Project# 1010581

16DRB-70023 EPC APPROVED SDP FOR BUILD PERMIT

DATE: January 22, 2016
TO: Jack Cloud, DRB Chair
FROM: Catalina Lehner, Senior Planner *CLL*
RE: Project #1010581, Tramway Taproom
Zone Change and As-Built Site Development Plan for Building Permit

Re: **Existing Canyon Plaza Development at: 417 Tramway Boulevard NE
Zone Map Amendment and Site Development Plan for Building Permit
Project Number #1010581
EPC Number # 15EPC-40045 and 15EPC-40046**

11 Existing Building Mounted Signage
Scale: Not to Scale

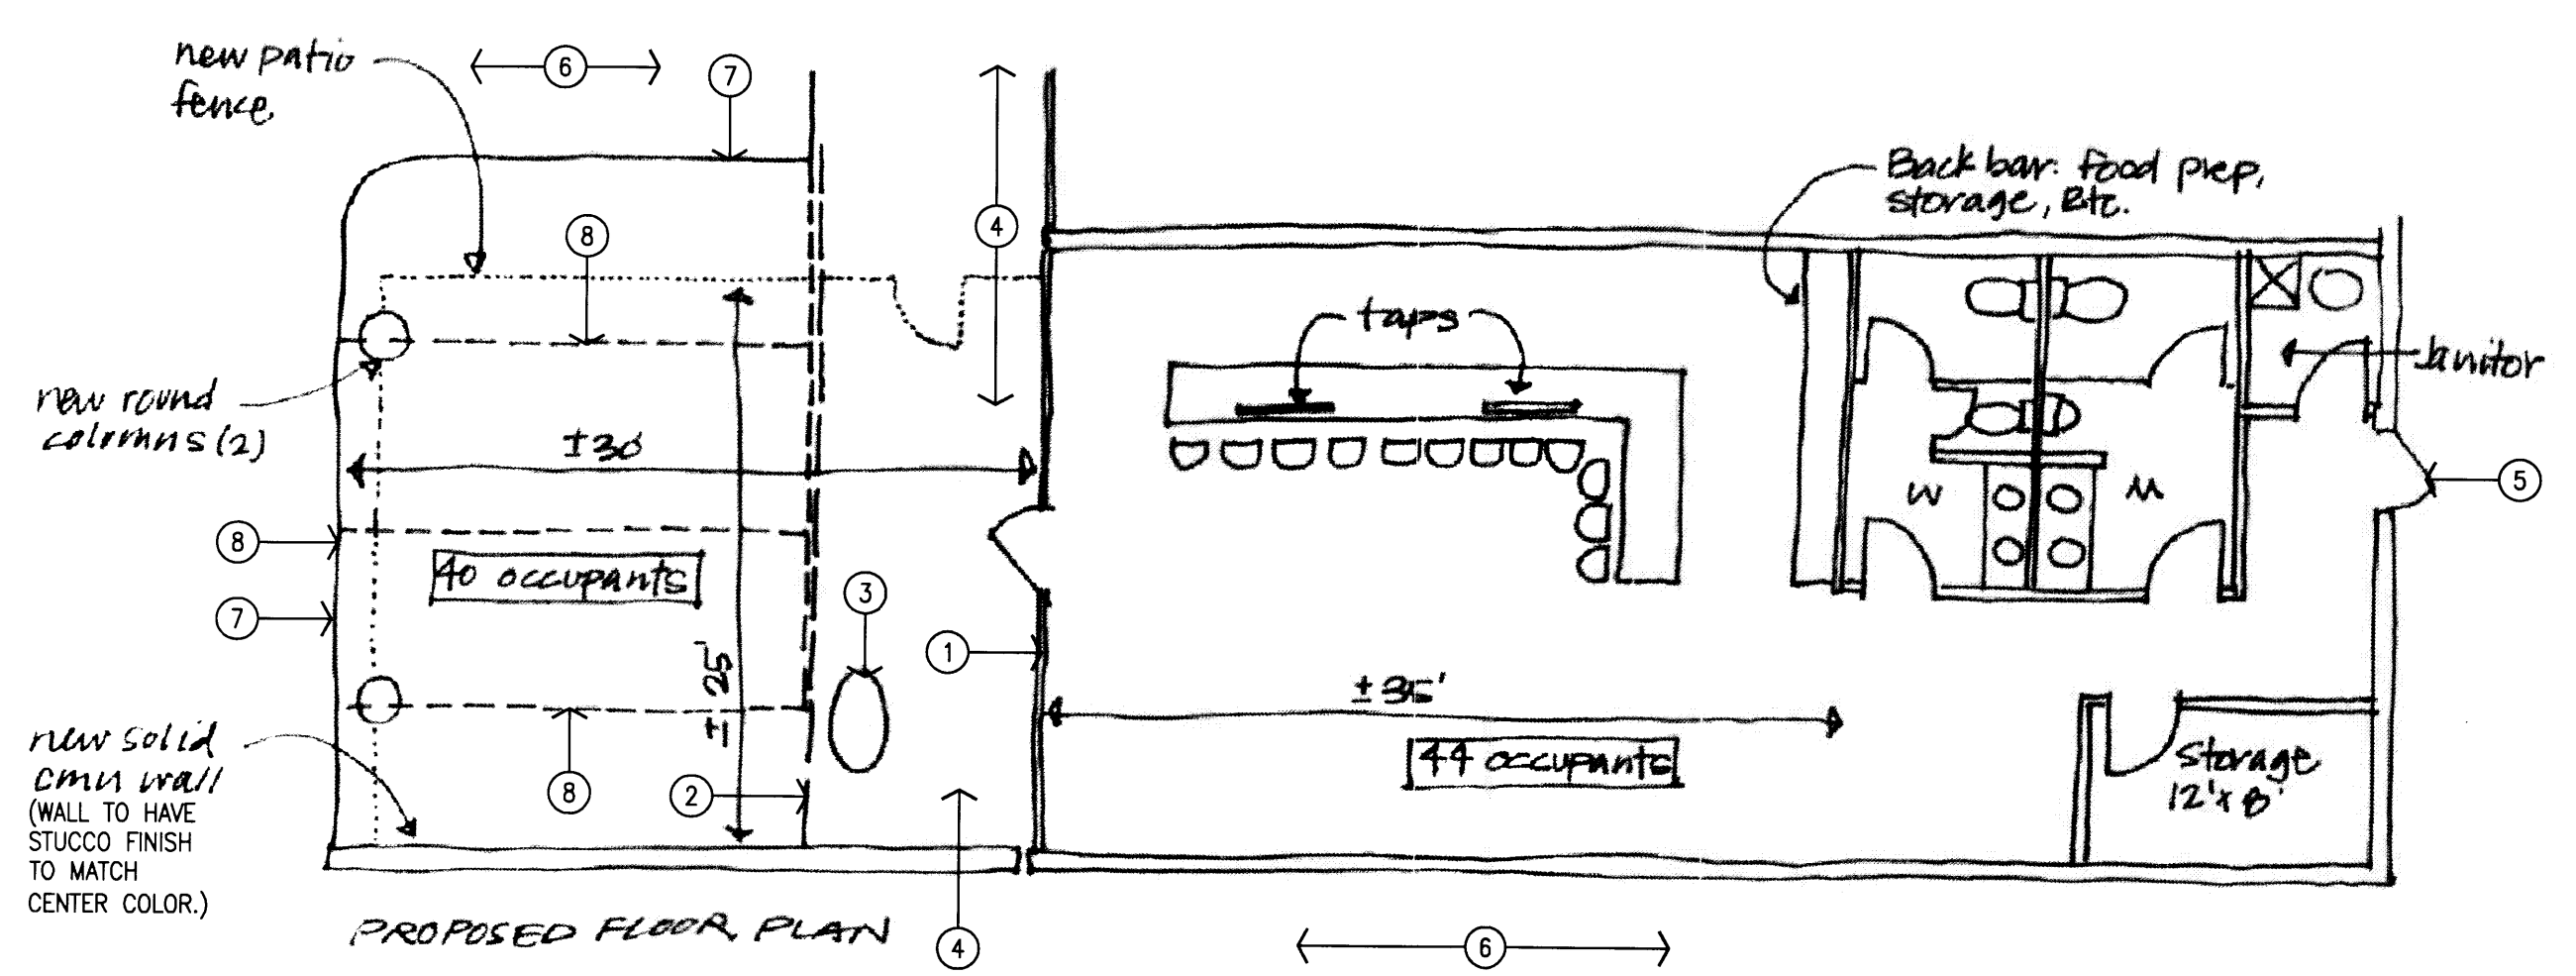
- B. *Building mounted signage shall be indicated and dimensioned on the elevations.*

Photos were added of the existing pylon, monument and building mounted signage. Refer to page 1 of 4. General Note "D" also enforces that "ALL SIGNAGE IS UNDER SPERATE PERMIT AS DIDICATED BY THE ZONING CODE".
